Application for Planning Permission

Development: Partial demolition of agricultural building and erection of 1 No dwelling. This application is a Departure from the Development Plan and is in CIL Zone 3 and is CIL Liable as a new dwelling.

Location: Rookery Farm Flansham Lane Felpham PO22 6EP

ROOKERY FARM
1:10,000 SCALE

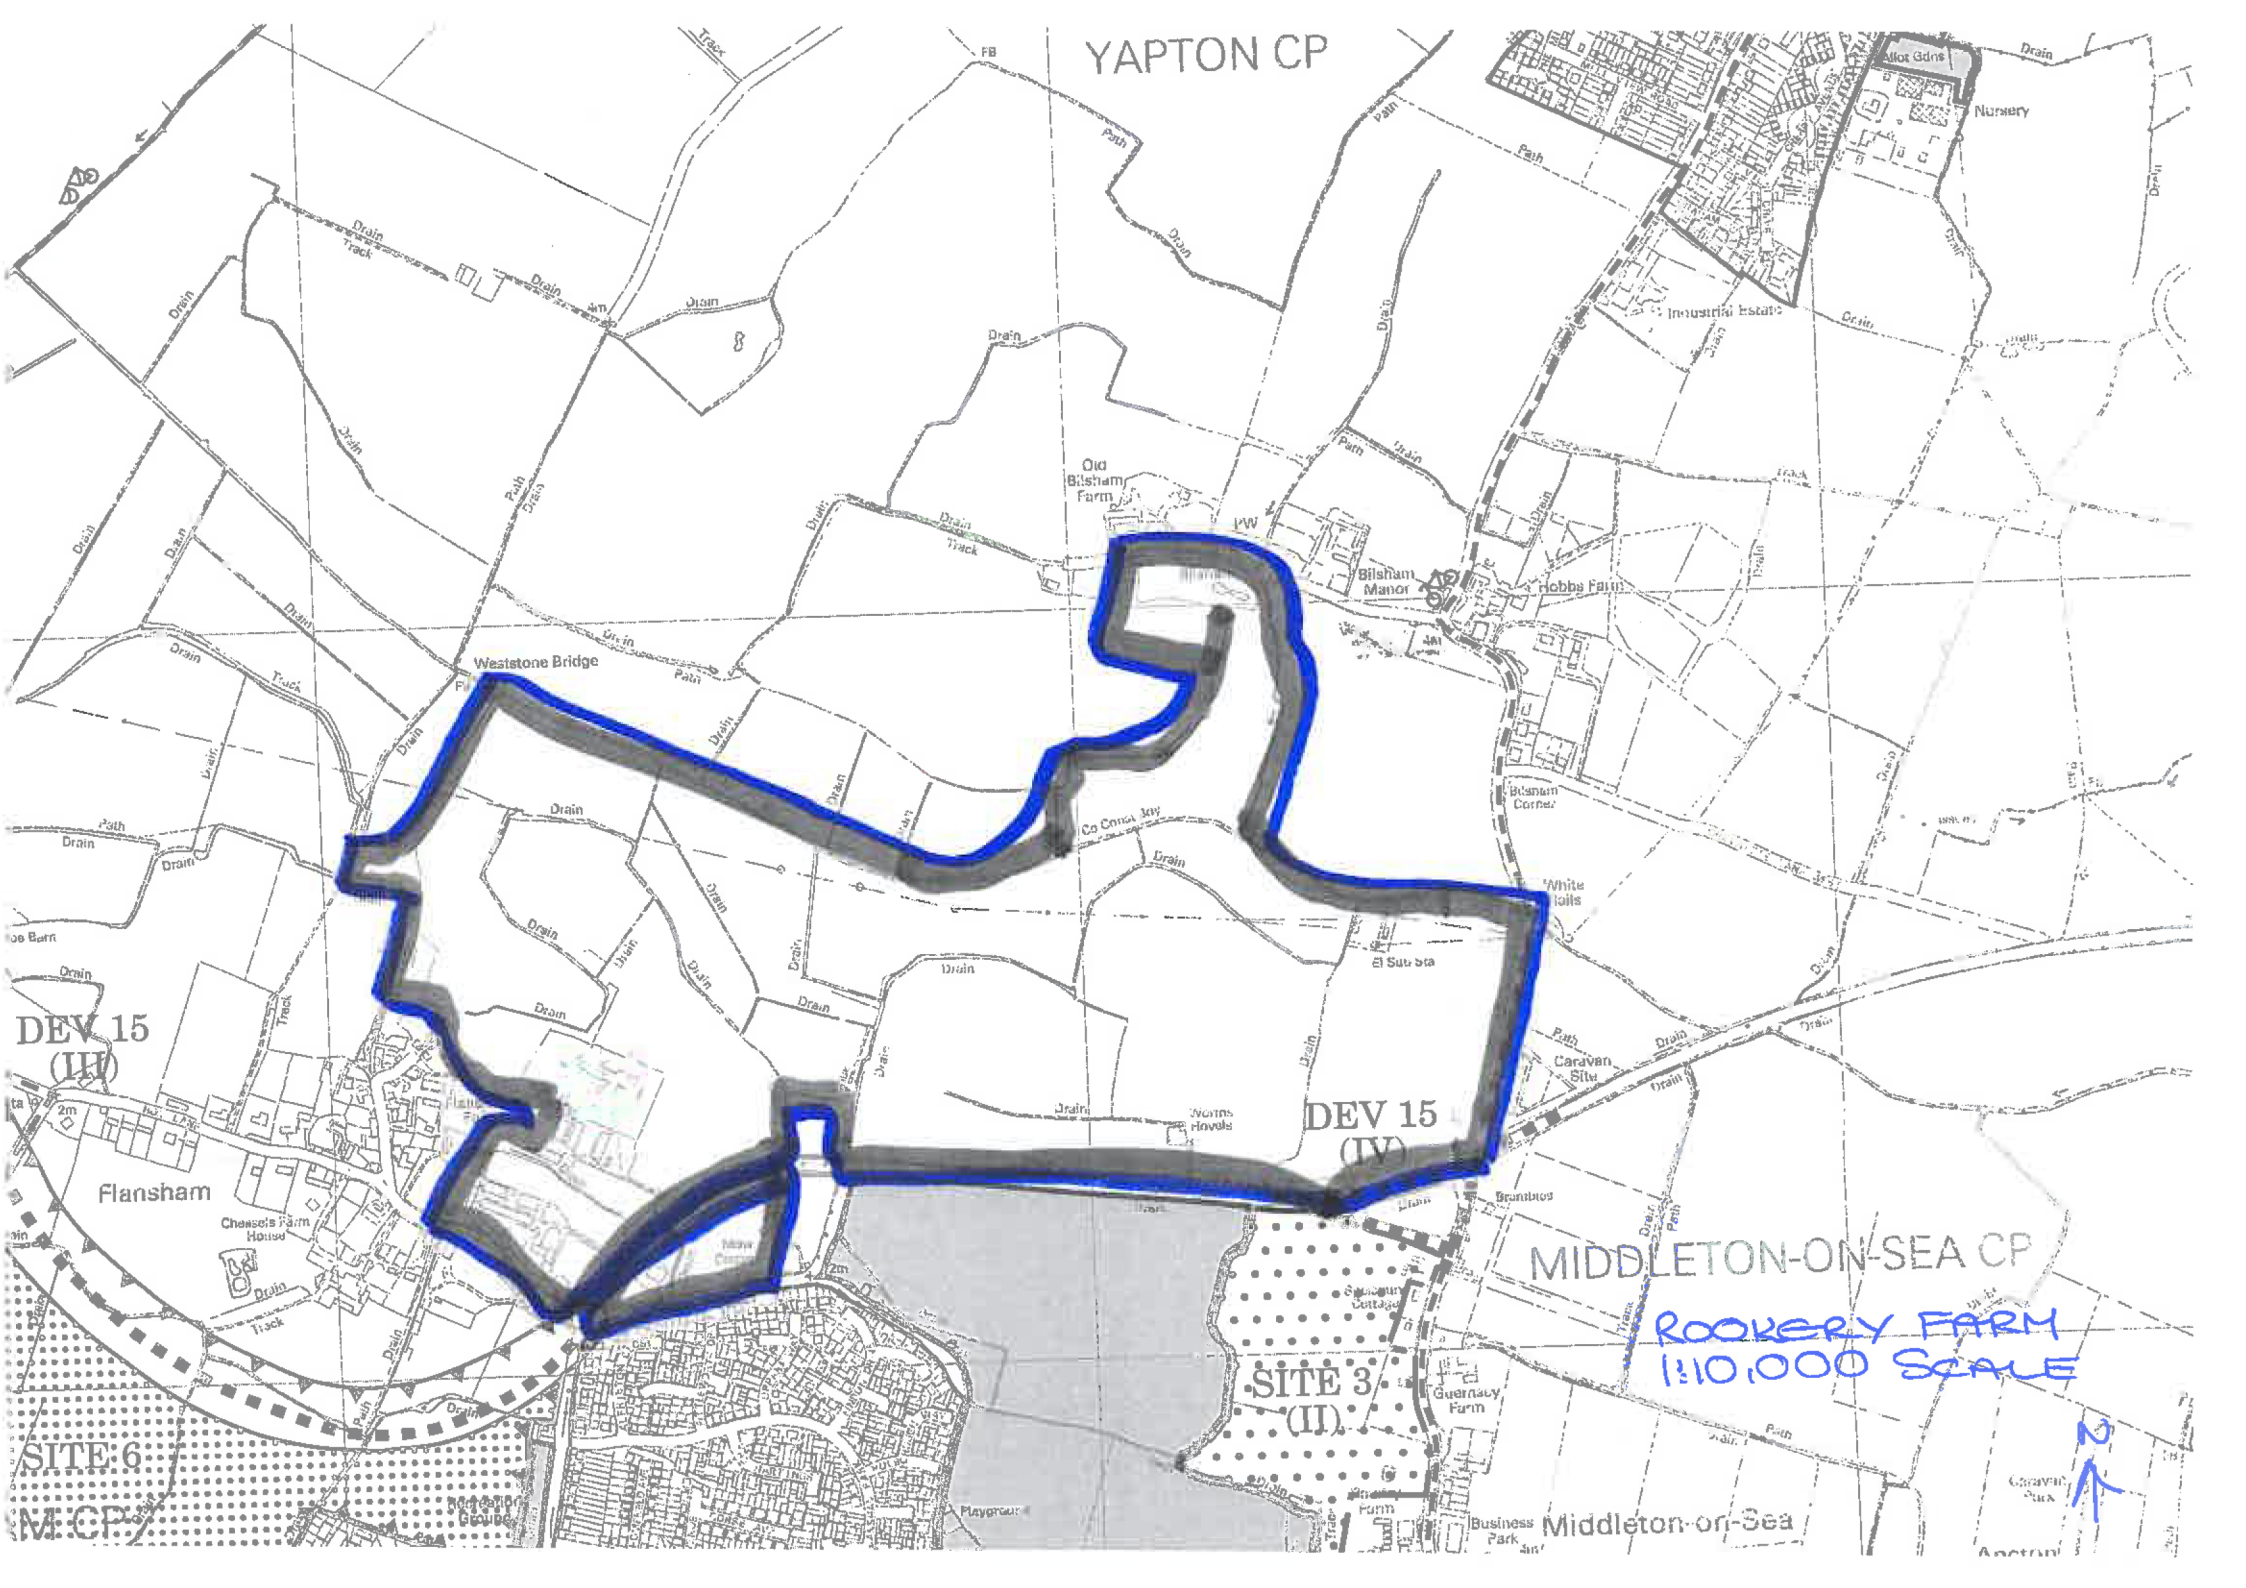
Location Plan

Please provide a full blue edge.
